From: [REDACTED]
To: [Metrowest1](#)
Subject: Portishead Branch Line - Metrowest Phase 1: Issue Specific Hearing 2, 11 Jan 2021
Date: 13 January 2021 14:40:32

Subject: Contractors access at [REDACTED]

Metrowest DCO Application Plans: 2.23

COMPOUNDS, HAUL ROADS  
 AND ACCESS TO WORKS PLAN  
 SHEET 6  
 PILL

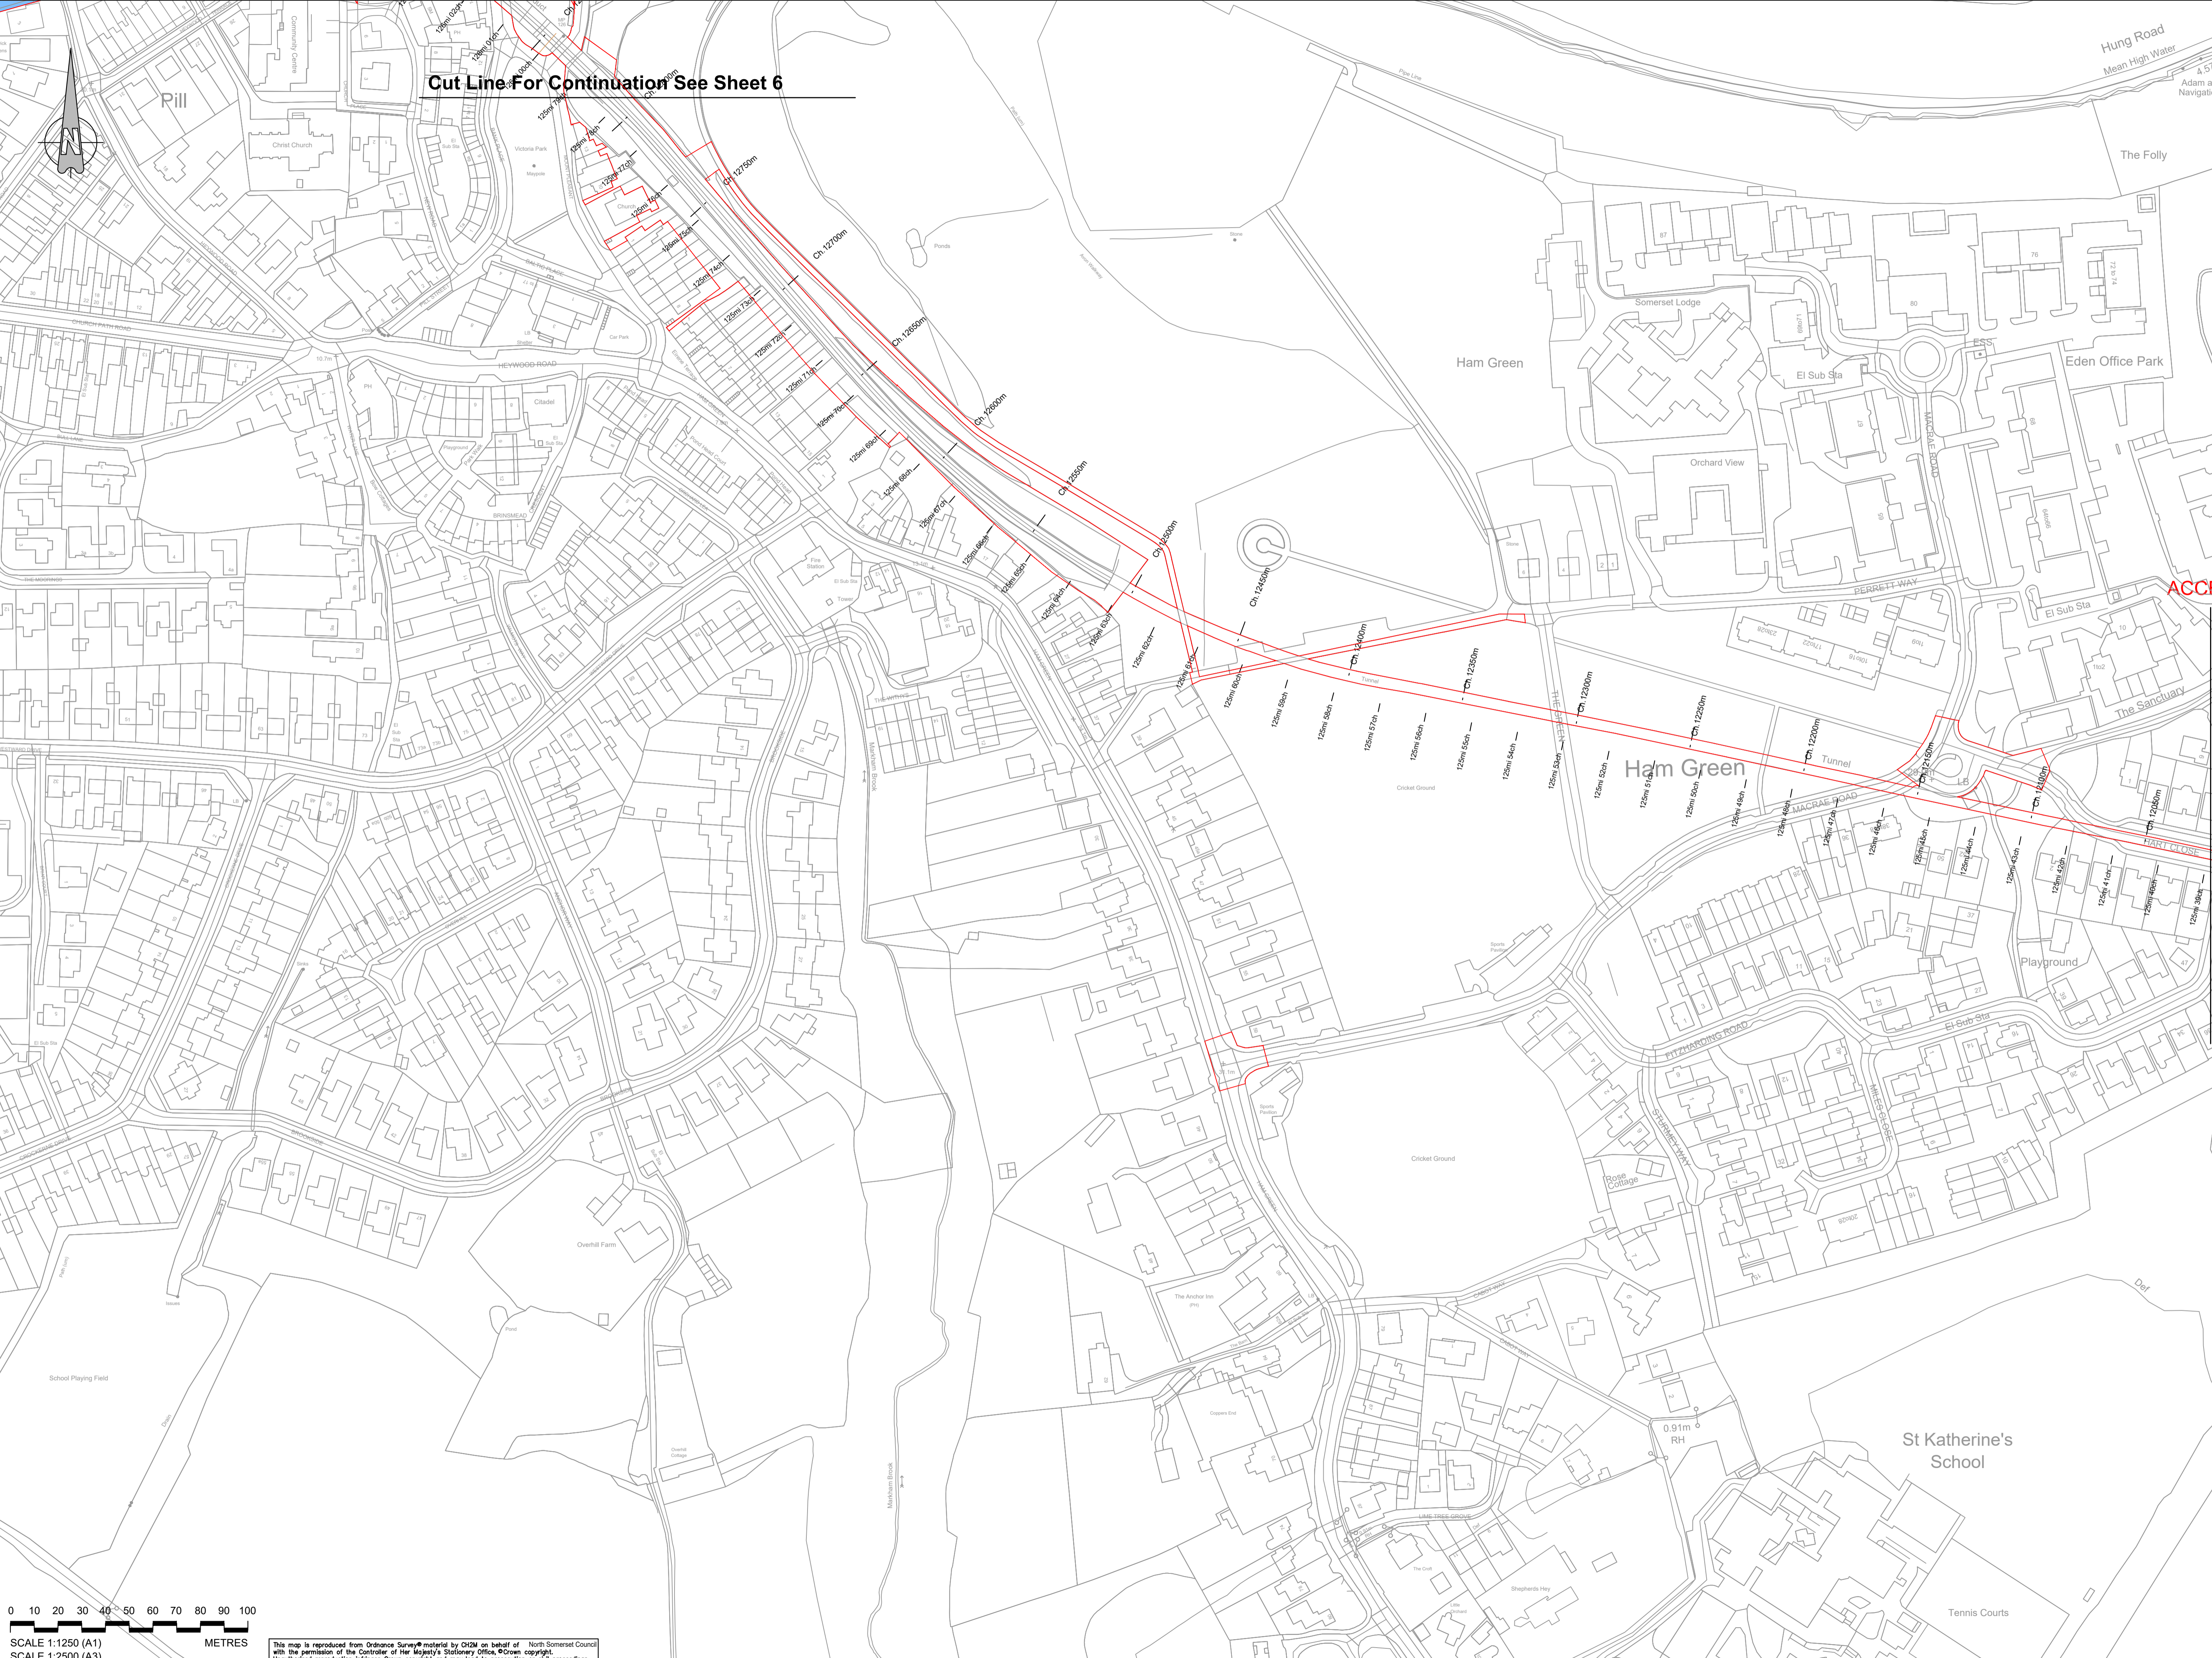
The DCO Application Plan 2.23 shows access to the embankment has been recorded alongside [REDACTED]. However, I am very concerned that this is not a suitable access route and would like it not to be used.

Whilst this access could be used by a small number of personnel, it is far too narrow for conveying machinery and materials which could cause significant damage to the property. The frailty of the pathway (which includes an inspection chamber) and the vulnerability of the rear corner and side of the house are cause for concern. The house construction is of double engineering brick (no cavity) and there are no foundations. Also the wall coating is of a special type which, once breached is difficult to repair sufficiently to retain its waterproofing qualities, thus allowing damp to penetrate the wall. There is also a gas pipe and an overflow pipe on the wall. I have attached three photographs to indicate these points and the narrowness of this access, particularly to the rear of the property. Vegetation and gardening materials can, of course, be removed but this does not significantly improve the situation.

As shown on the plan, access to the embankment has already been identified through the Methodist Church ([REDACTED]) so this could be used in place of access through [REDACTED]. Alternatively, there are only four houses in this terrace and access could be gained at the other end of the terrace ([REDACTED]).
